Subject: Romani Battery Energy Storage System (BESS) (SSD 67105475) EIS

ATTACHMENT A – RD Assessment Summary for Romani BESS Environmental Impact Statement (SSD 67105475)

RD has reviewed the flood risk management component in Section 6.9 of the EIS and Appendix O, Surface Water Impact Assessment (SWIA) (Engeny, 2025).

F6-2 Threatened Flora Species

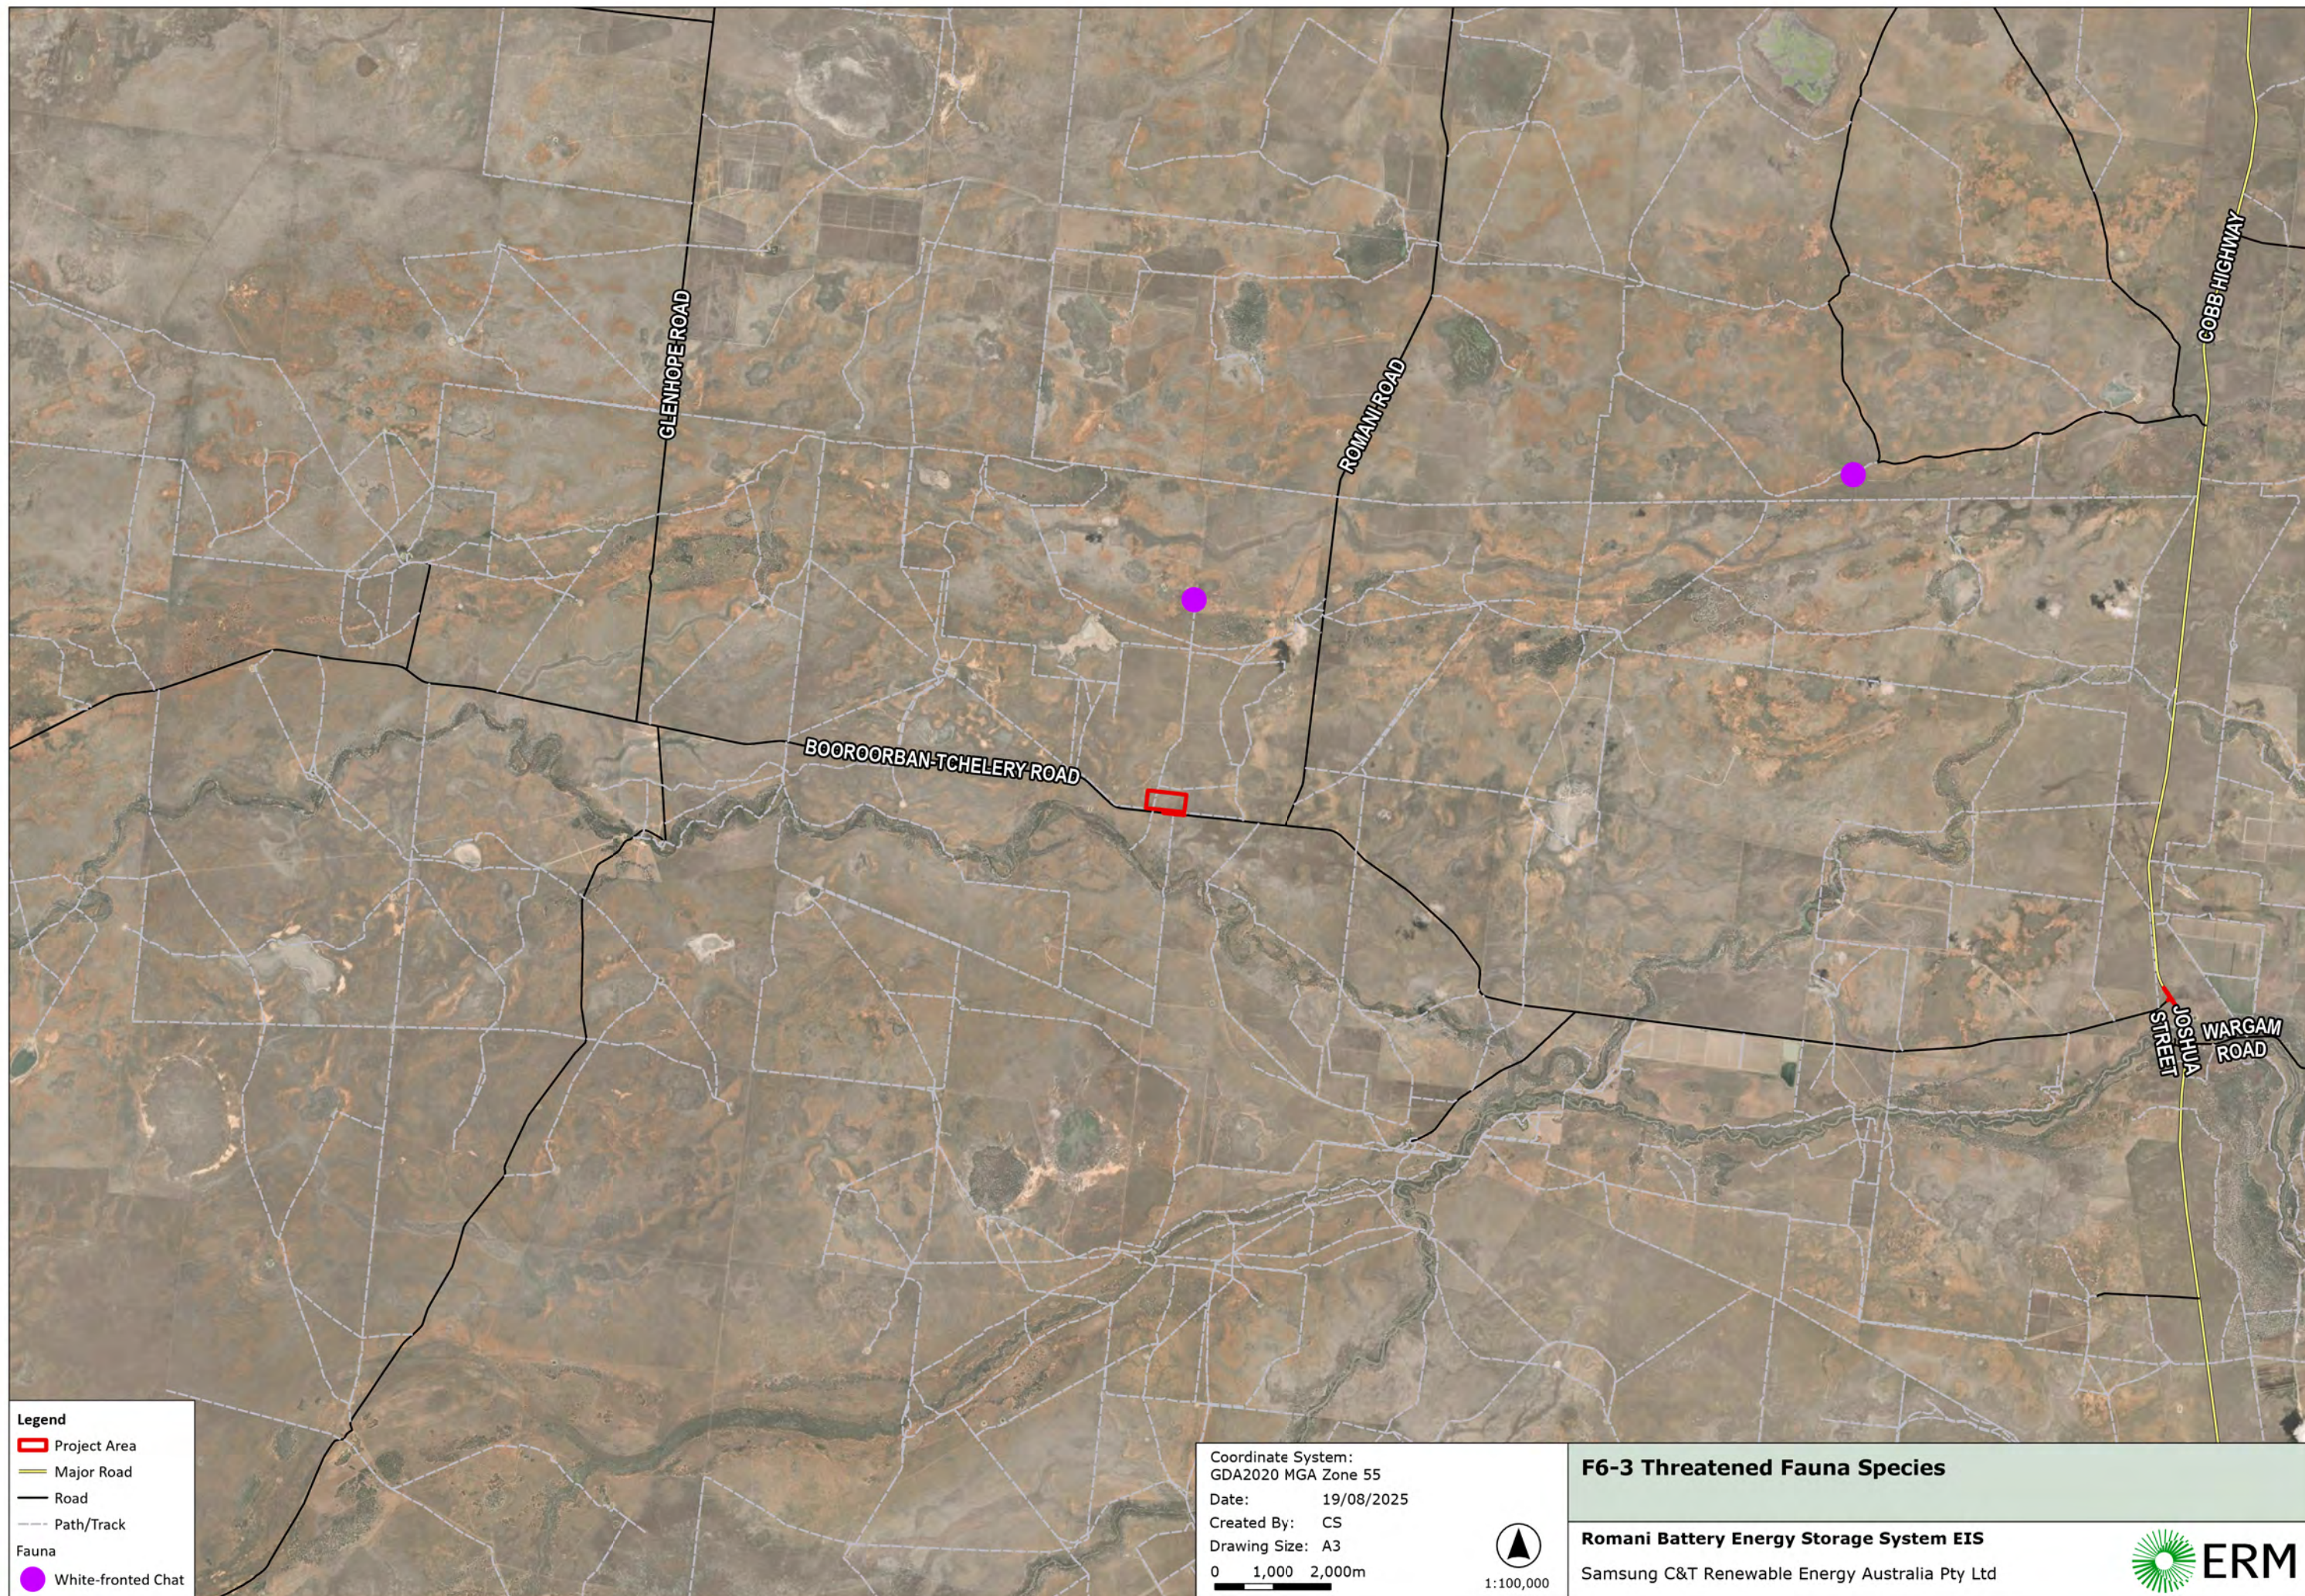
Maireana cheelii, *Swainsona murrayana* and *Lepidium monoplacoides* were all recorded in the original larger footprint and there is a reasonable likelihood that these species occur in the unsurveyed parts of the smaller BESS disturbance footprint.

- 6.1. Provide a map showing the locations of all threatened flora species observed and consult further with RD to confirm whether further surveys or assessment is required.
